LSC TRANSPORTATION CONSULTANTS, INC.
545 East Pikes Peak Avenue, Suite 210
Colorado Springs, CO 80903
(719) 633-2868
FAX (719) 633-5430
E-mail: lsc@lsctrans.com
Website: <http://www.lsctrans.com>

MEMORANDUM

SUBJECT: Lorson Ranch East
(PUDSP-16-003) Review 2
Response to Comments Memorandum
LSC #164360

Following are the LSC Transportation Consultants, Inc. responses to the August 15, 2017 El Paso County Planning and Community Department comments letter regarding the July 12, 2017 Updated Traffic Impact and Access Analysis by LSC.

Figure 6

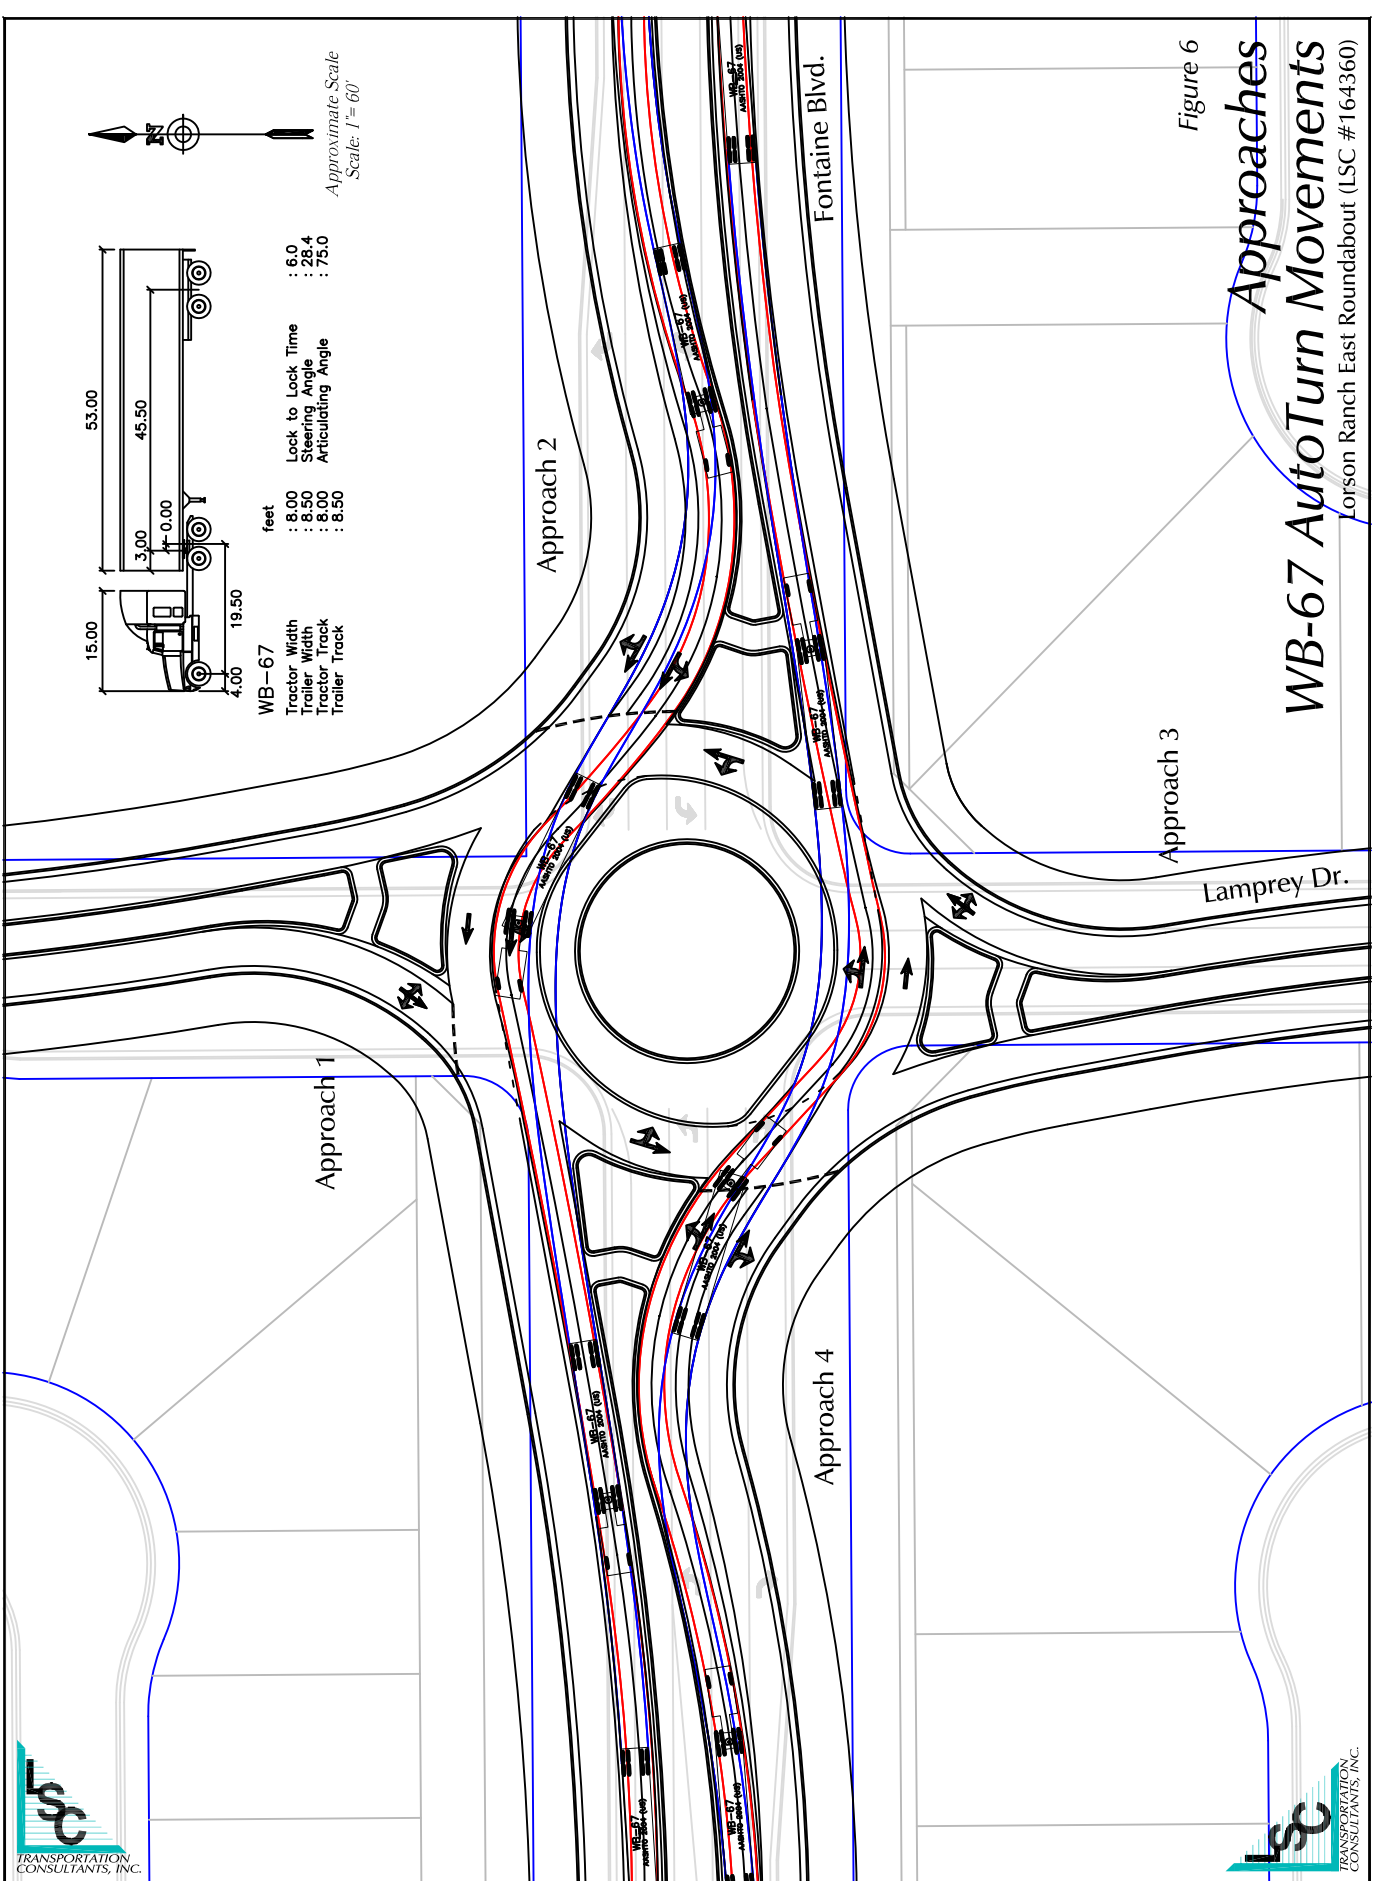
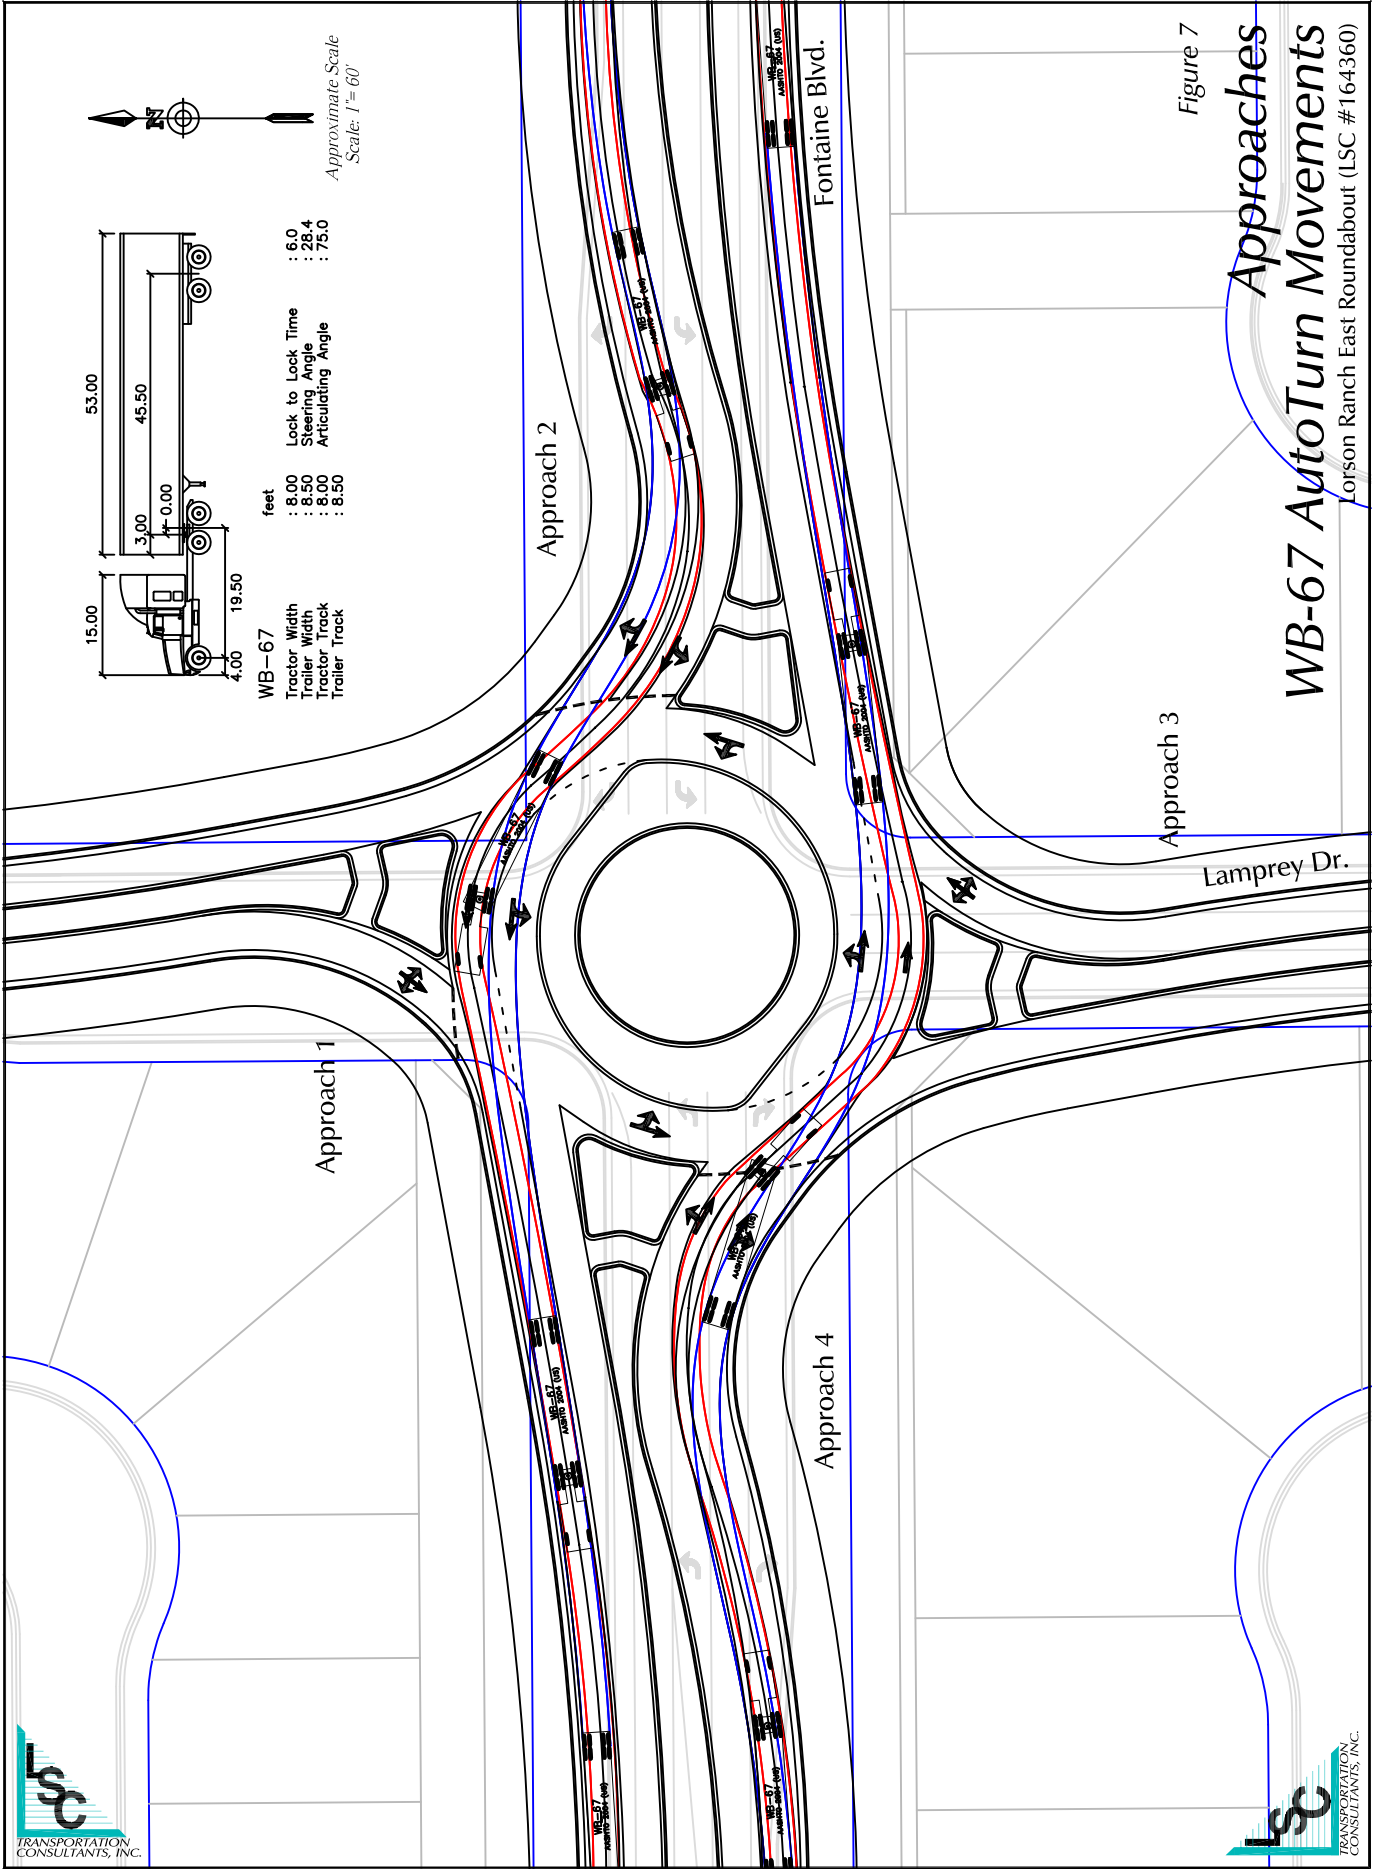
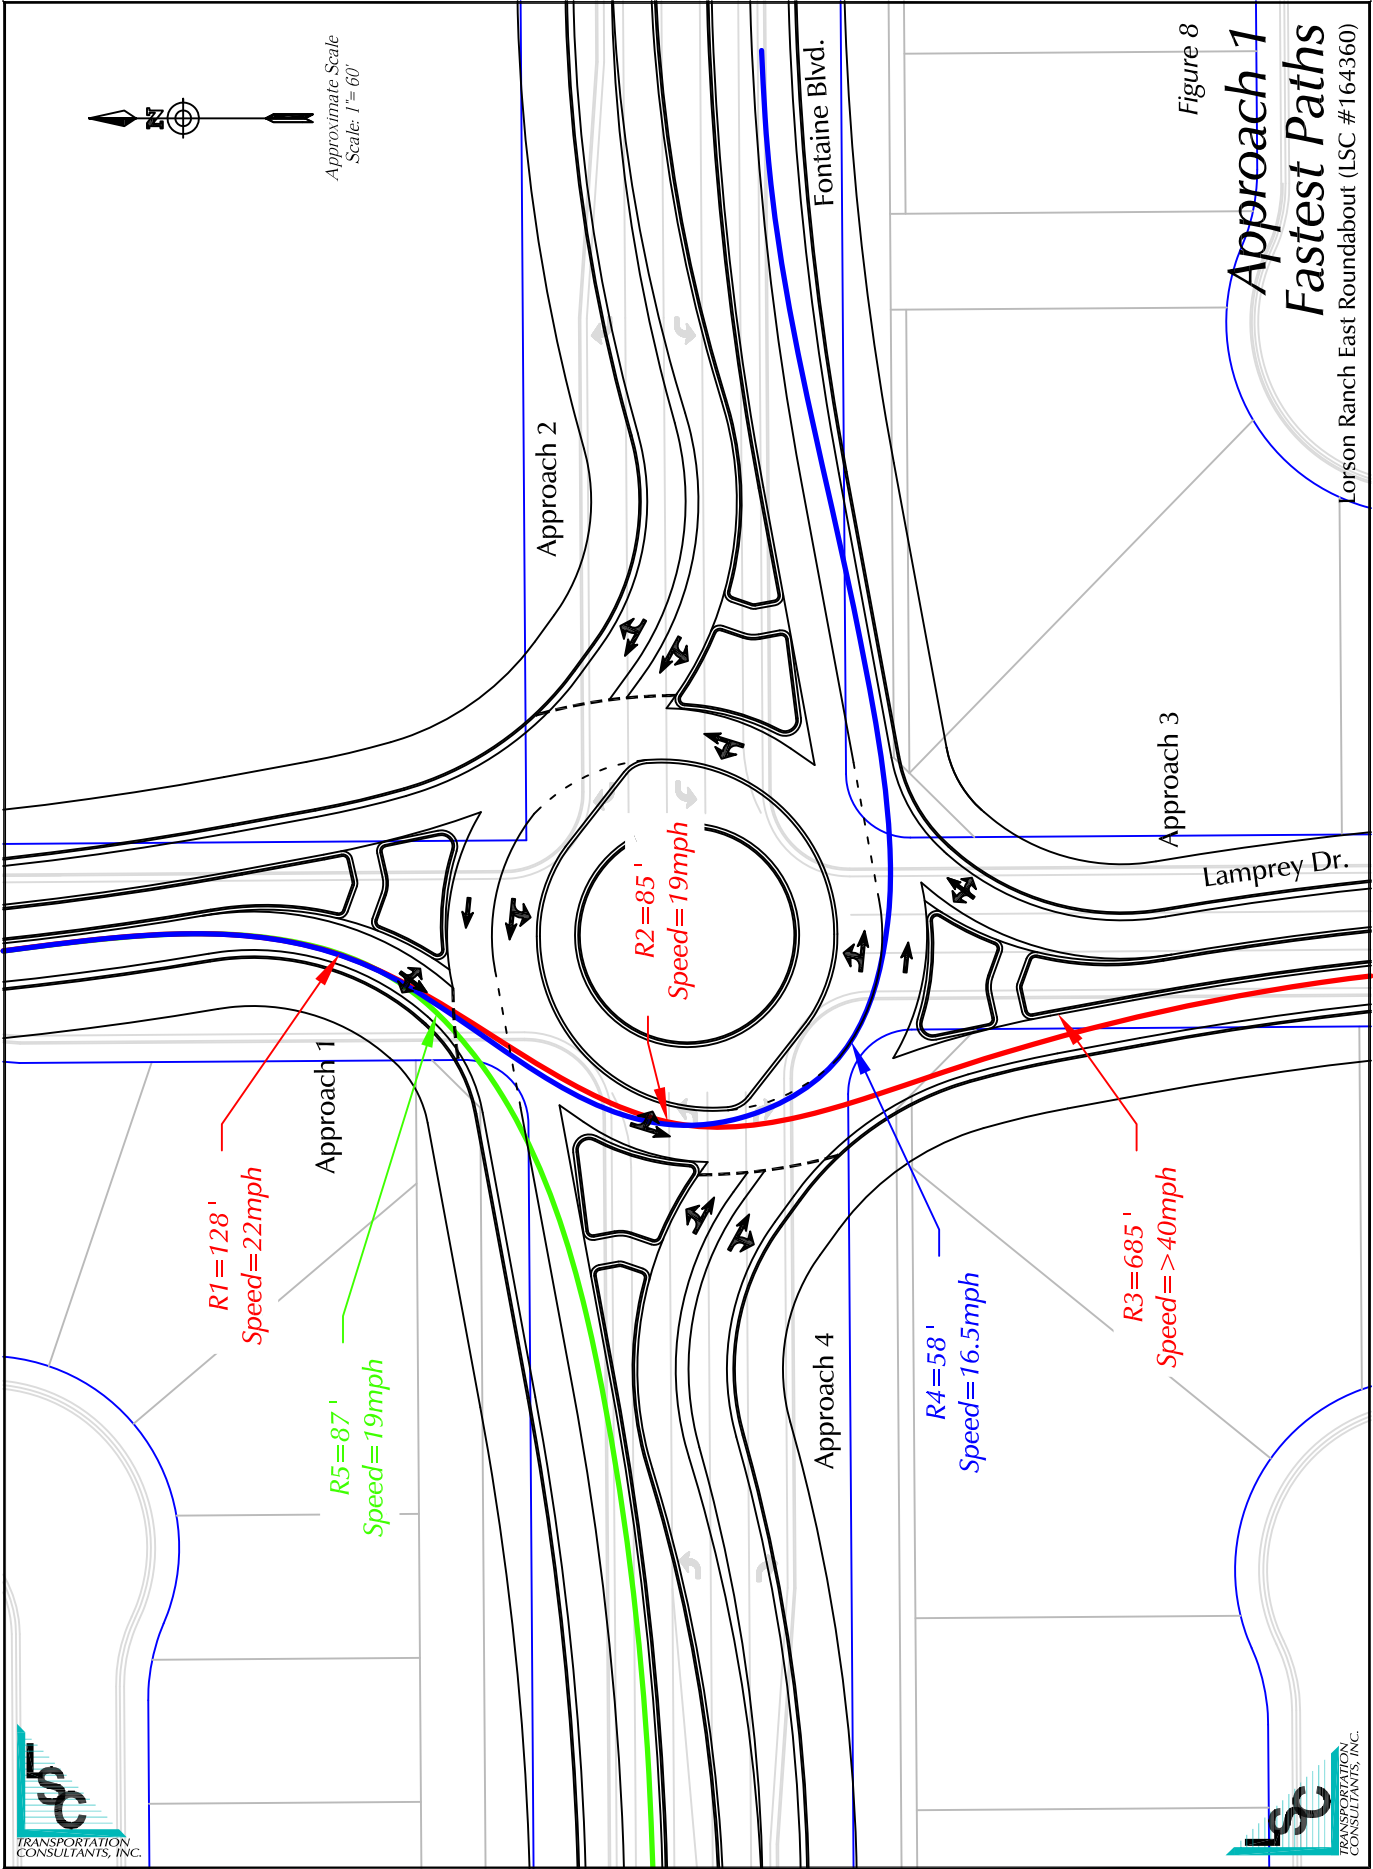
8. *Regarding the e-mailed comments dated March 17, 2017:*
*a. **It needs to be clearly documented that the roundabout is the proposed intersection at Lamprey/Fontaine. If the roundabout is the chosen option, could it not be designed to be expandable to 2-lanes when necessary along with widening of Fontaine Blvd.?***

LSC Response: The updated TIS clarifies this and clearly presents the roundabout as the proposed solution. The report also includes a roundabout design report and exhibits with the design of a future two-lane roundabout.
